**NWS-2022-337; Marysville, City of (Geddes Marina Phase
2 Remediation) Joint Public Notice dated 7 April 2023
Summary of Public Comments Received through 7 May
2023**

Name	Relationship	Concern
#1	Laura M. Gurley	Director of Planning, Port of Everett	Requests to review Biological Assessment and/or mitigation plan
#2	Roderick "Rod" Malcom	Biologist/Ecologist, Suquamish Tribe	Inquired about the proposed barge use and imported fill material

**CHANNEL PROFILES**

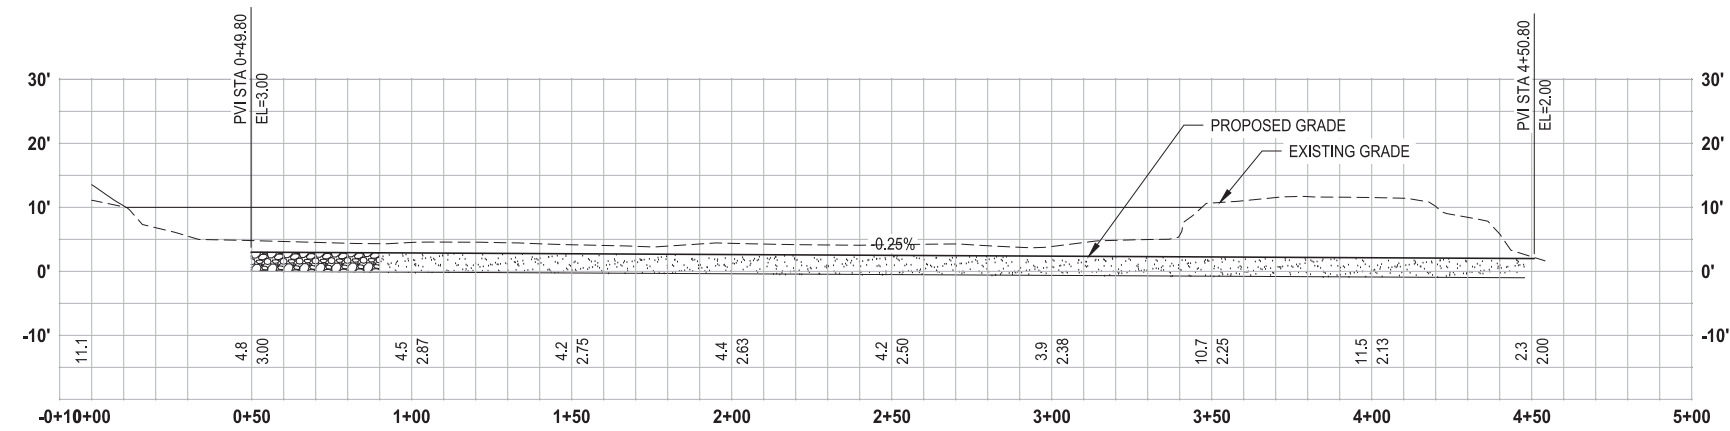
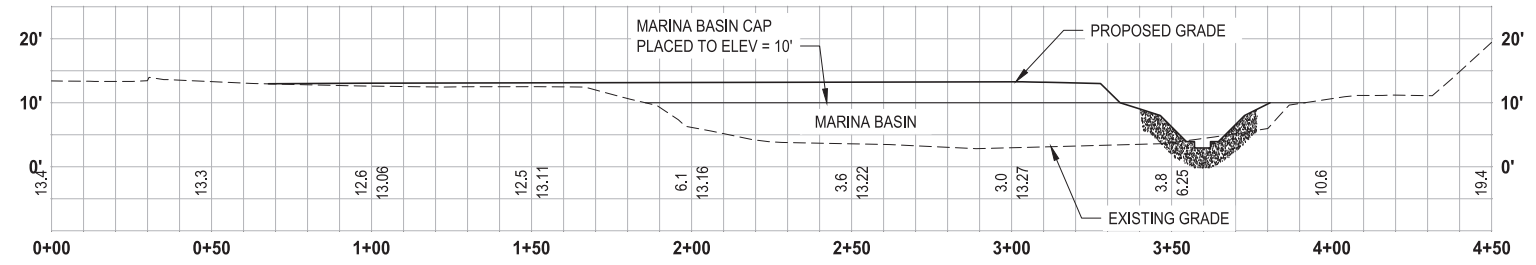
#7	Todd Gray	Environmental Protection Ecologist, Tulalip Tribes	Inquired about proposed design elements and proposed alternatives. Concerned about transmission of contaminated sediments and groundwater into Ebey Slough and the proposed conveyance channel.

Channel Design. To clarify, the referenced 2019 channel design was developed for a different project with different project goals. At the time, the proposed channel was intended to be a backwater habitat feature and was intended as mitigation for project specific impacts associated with proposed new overwater structures. The project that the 2019 channel design was associated with was determined to be infeasible following completion of additional on site investigations conducted for the RI/FS study and site specific geotechnical work conducted for the proposed project and the adjoining City stormwater retrofit project. All applications for that project have been withdrawn.

The City recognizes that the proposed channel does not represent natural conditions or provide significant habitat value. That is no longer the purpose of that project element. The channel is necessary to convey stormwater from the stormwater retrofit project over the sediment cap to Ebey Slough. The proposed streambed aggregate and rock armoring are necessary to protect the cap from scour during large stormwater events.

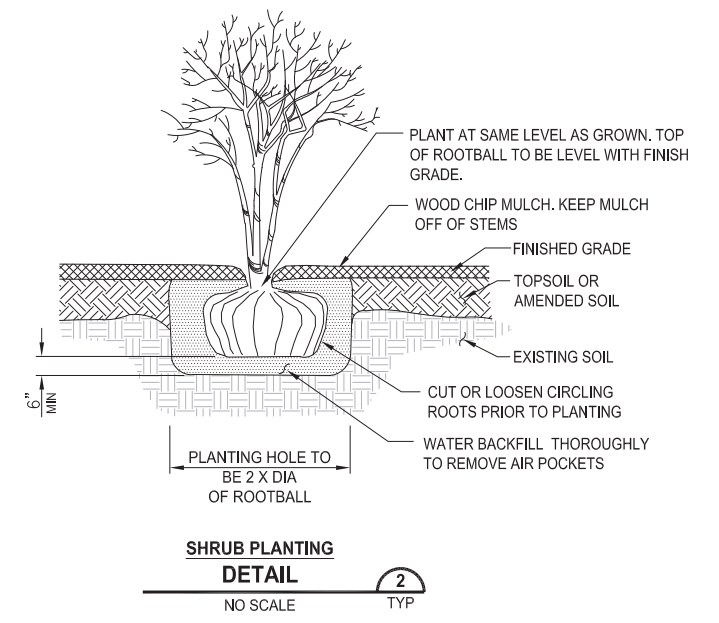
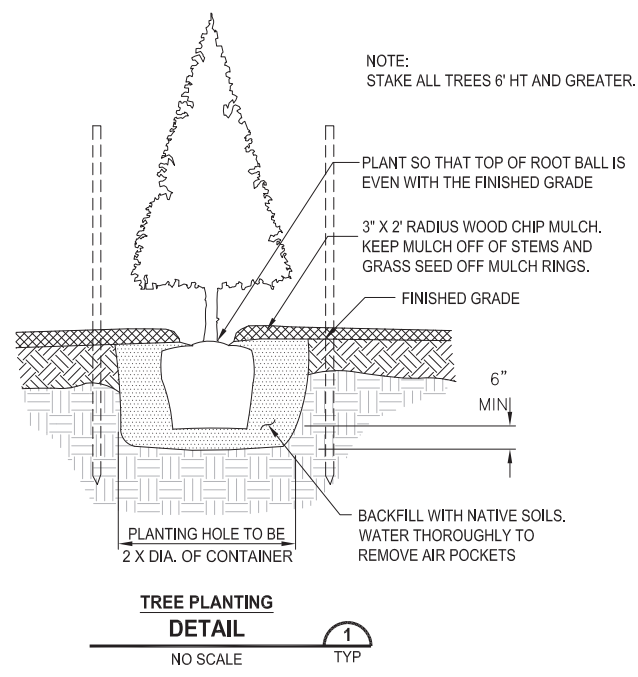
Proposed Plantings. As noted in the channel design comment, the project is different from the project that the City originally proposed on this site. The areal extents of the project are similar, including the planting areas, but the proposed site elevations have changed. The site is being filled to be above the high-water elevation and the site will be filled and graded to drain to prevent water from pooling on the cap and infiltrating into the contaminated material. As such, the elevation of the planting zones will be higher than previously proposed. However, the comments about plant selection are noted and appreciated. We will revise the proposed planting plan to reflect the recommendations.
